**Re: Dave and Busters Winrock  
Conceptual Grading and Drainage Plan  
Engineer's Stamp Date –sealed but not dated- (J19/D038)**

Based upon the information provided in your submittal received 9-26-13, the above referenced plan cannot be approved for Site Plan for Building Permit by the DRB until the following comments are addressed:

GRADING & DRAINAGE
PLAN

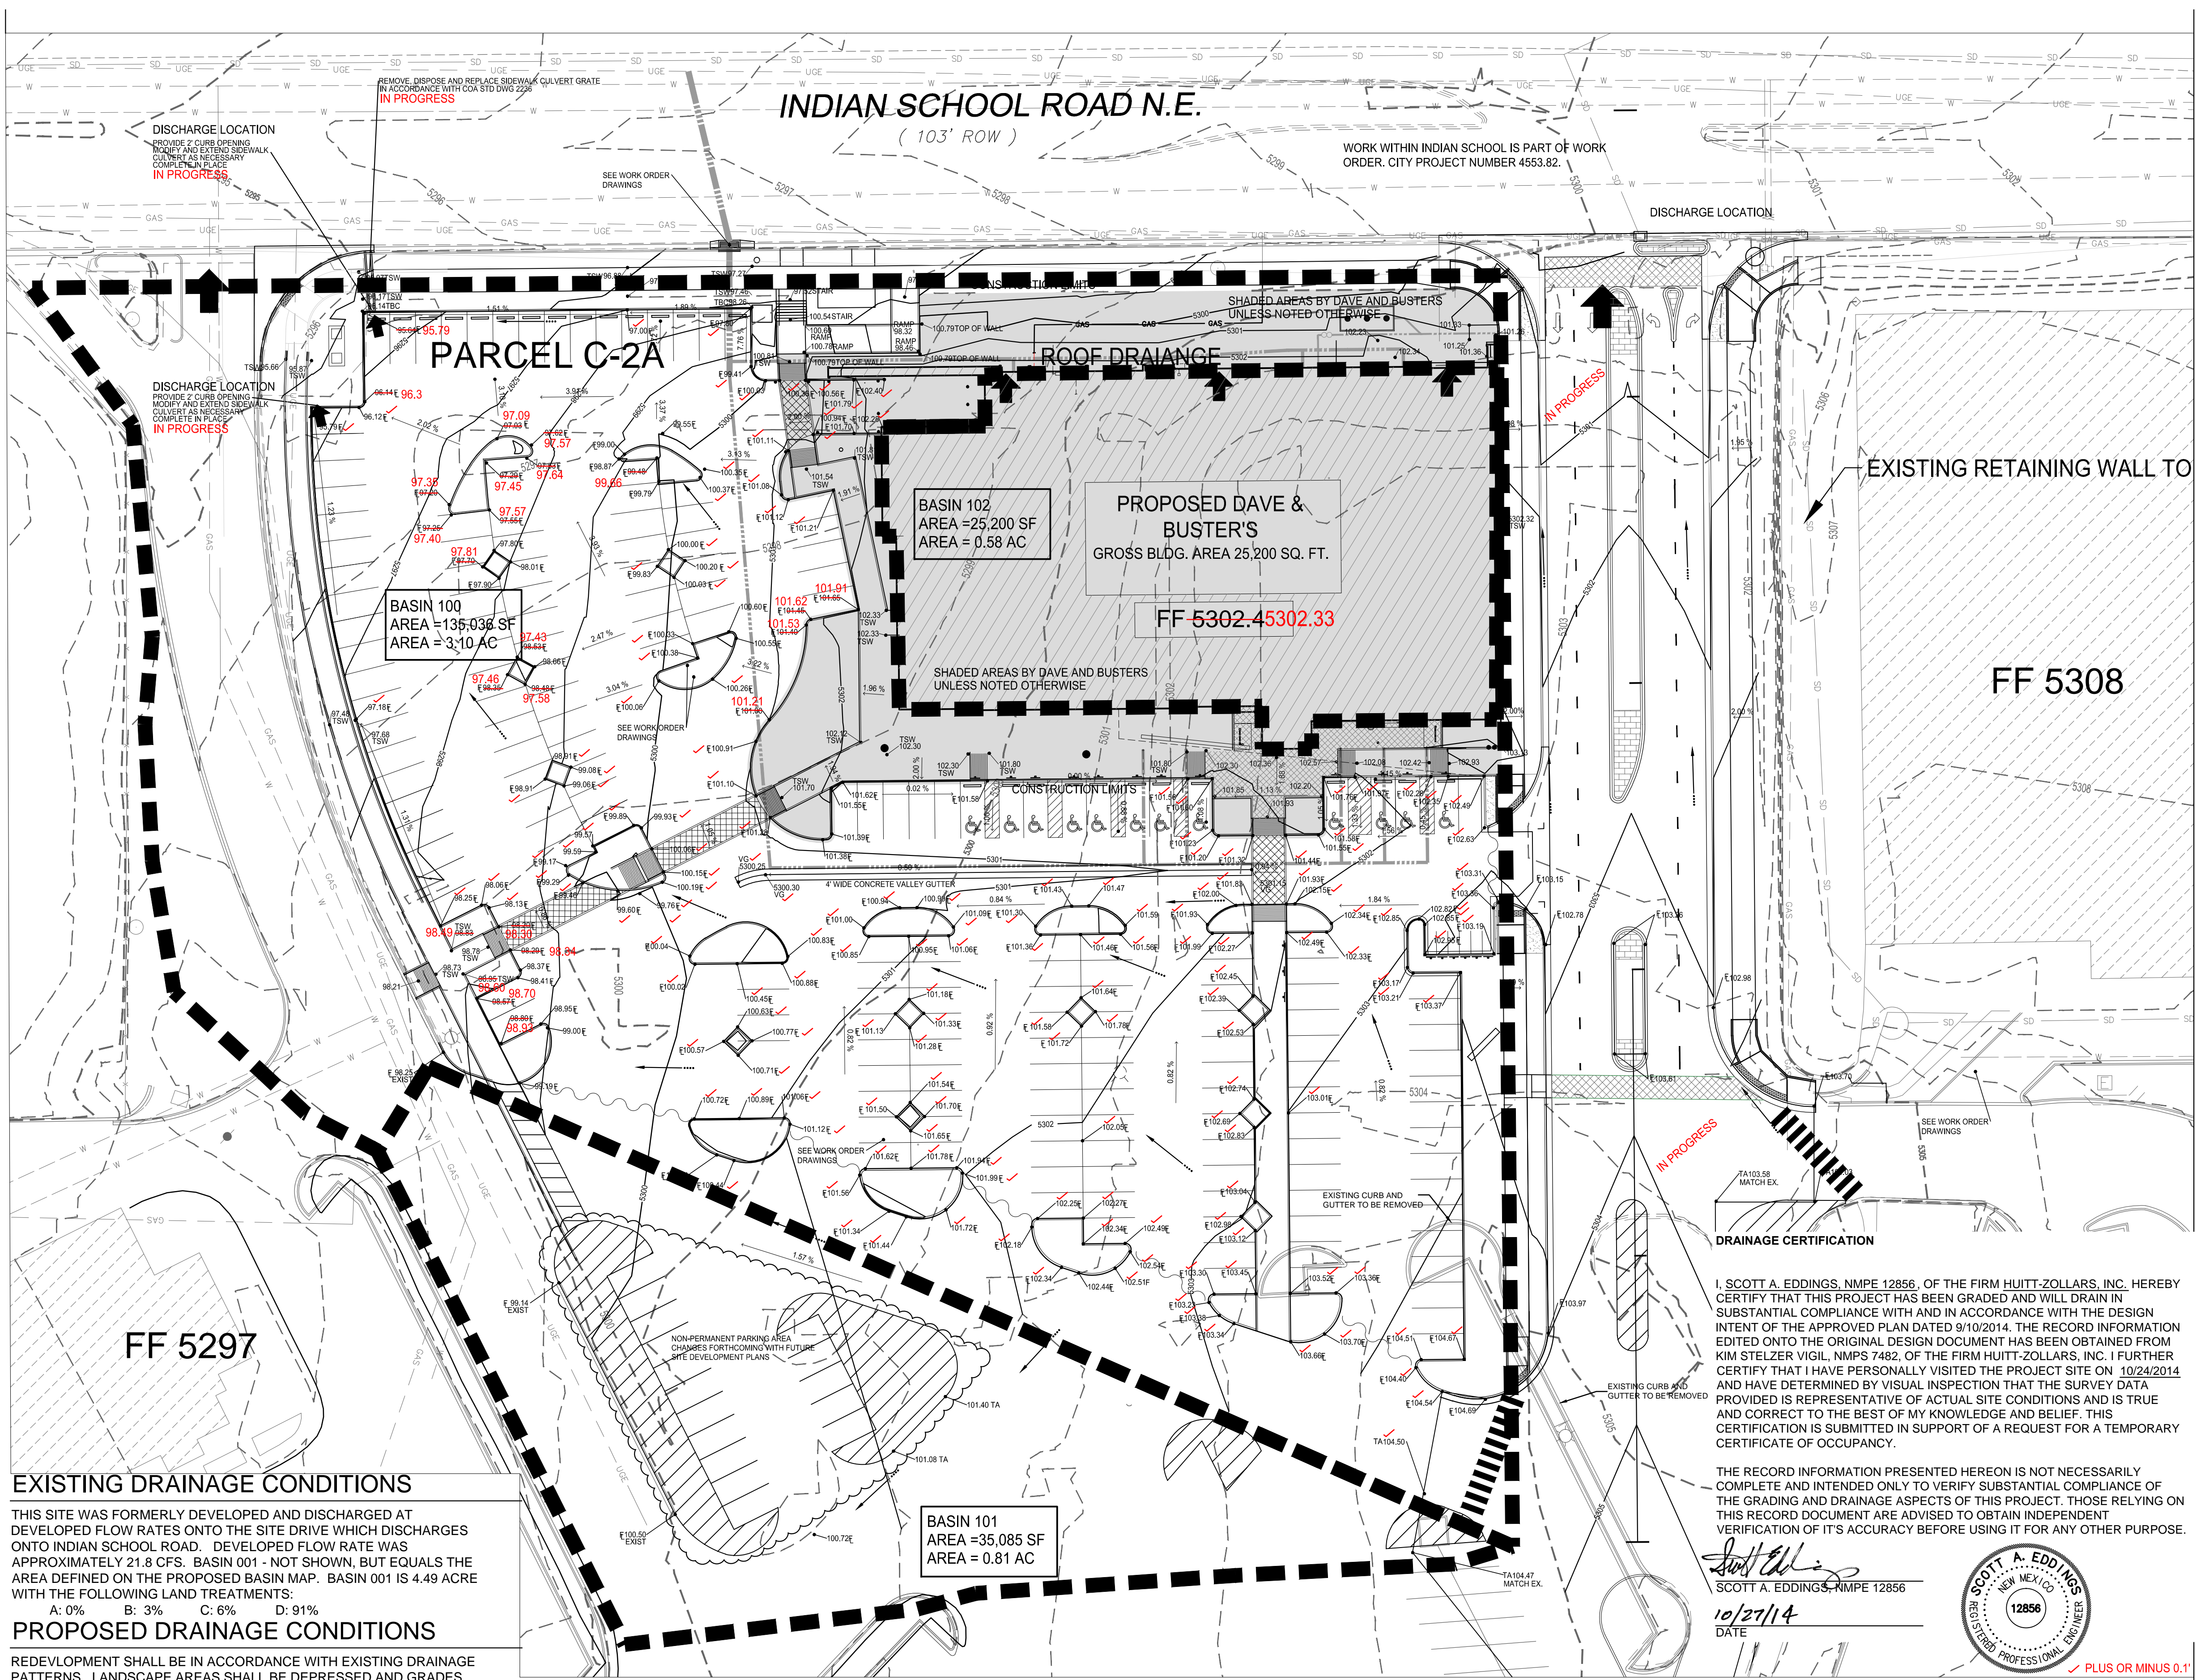
1. Toys-R-Us appears to have a 12" storm drain from their site to the existing inlet in the proposed entrance. It is difficult to tell how this proposed layout will affect it.
2. Storm drains are not to have an angle less than 90 degrees. This plan proposes an angle of 45 degrees.
3. How big is the manhole in Indian School Rd and is there room for another connection?
